From: Amanda Scholes on behalf of Planning.Responses
Sent: 14 July 2017 09:54
To: Planning Scanning
Subject: FW: CHECAA Objection (2) to AW/155/17/PL - Brus Lodge, 28 Kingsway - 12-7-2017. FRONT WALL CONSTRUCTION PLAN REQUESTED.

Subject: CHECAA Objection (2) to AW/155/17/PL - Brus Lodge, 28 Kingsway - 12-7-2017

Dwg No  
PL25

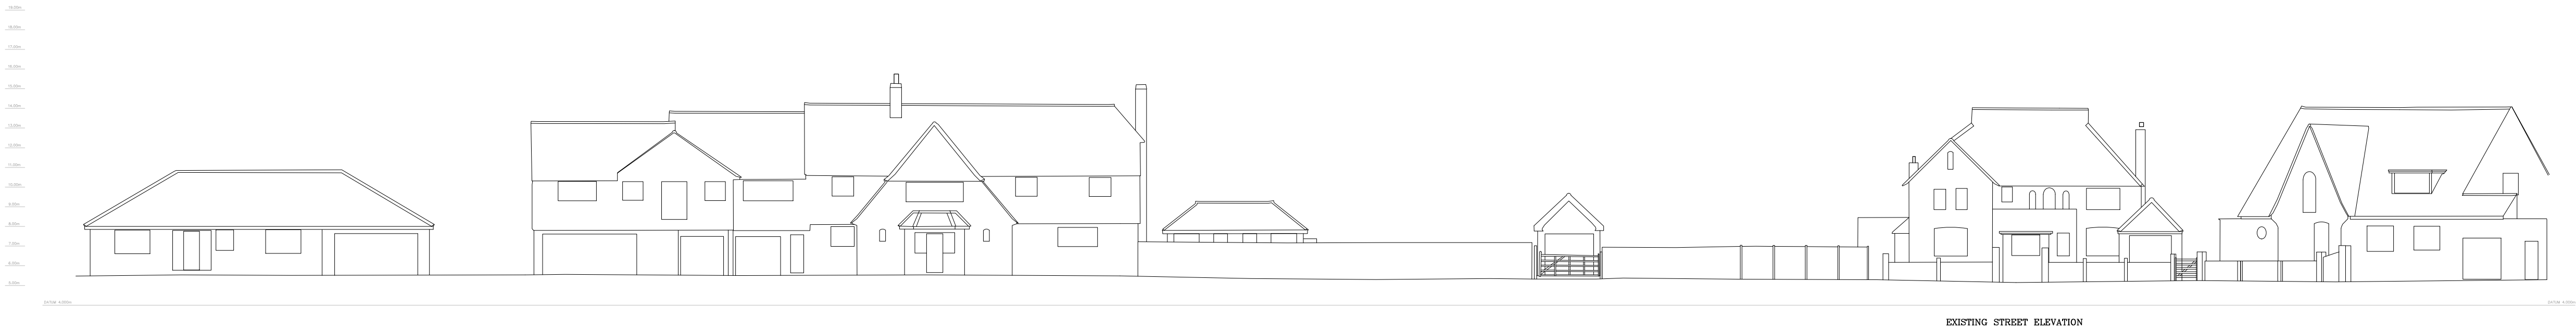
Thank you for this information but it is our view that, far from being what you describe as being '**...the proposed wall...**' in the street scene this is, as is described today by the Conservation/Design Officer, no more than '**...an indicative illustration...**'. **For Seaman to suggest that this is a scaled plan at 1:200 is ludicrous and certainly NOT the case – you are asking us to believe that those 5 houses, windows, roofs etc are drawn to scale is totally unrealistic and not the case!**

So, the detailed information of the wall – critically important for us to consider with a Consultant in connection with the harm it and its construction will cause to all the trees (including the one on the verge owned, with the verge, by the Estate Company and Residents and not Brus Lodge) is still requested, please.

Will you please receive and post on the website this further objection by CHECAA to AW/155/17/PL which calls for a fully detailed construction plan of the proposed front wall, including all dimensions and materials it is proposed to use including materials and colours of any gates, bricks and the like.

Thank you for your letter. I note that the design of the proposed wall is shown on the submitted streetscene drawing (dwg. TSP 481 PL25 A) and its dimensions can be scaled from this using the online tool. Furthermore, the application form indicates that new boundary walls will be constructed from brick. If permission was granted, a condition could be imposed requiring details of all materials including for the wall.
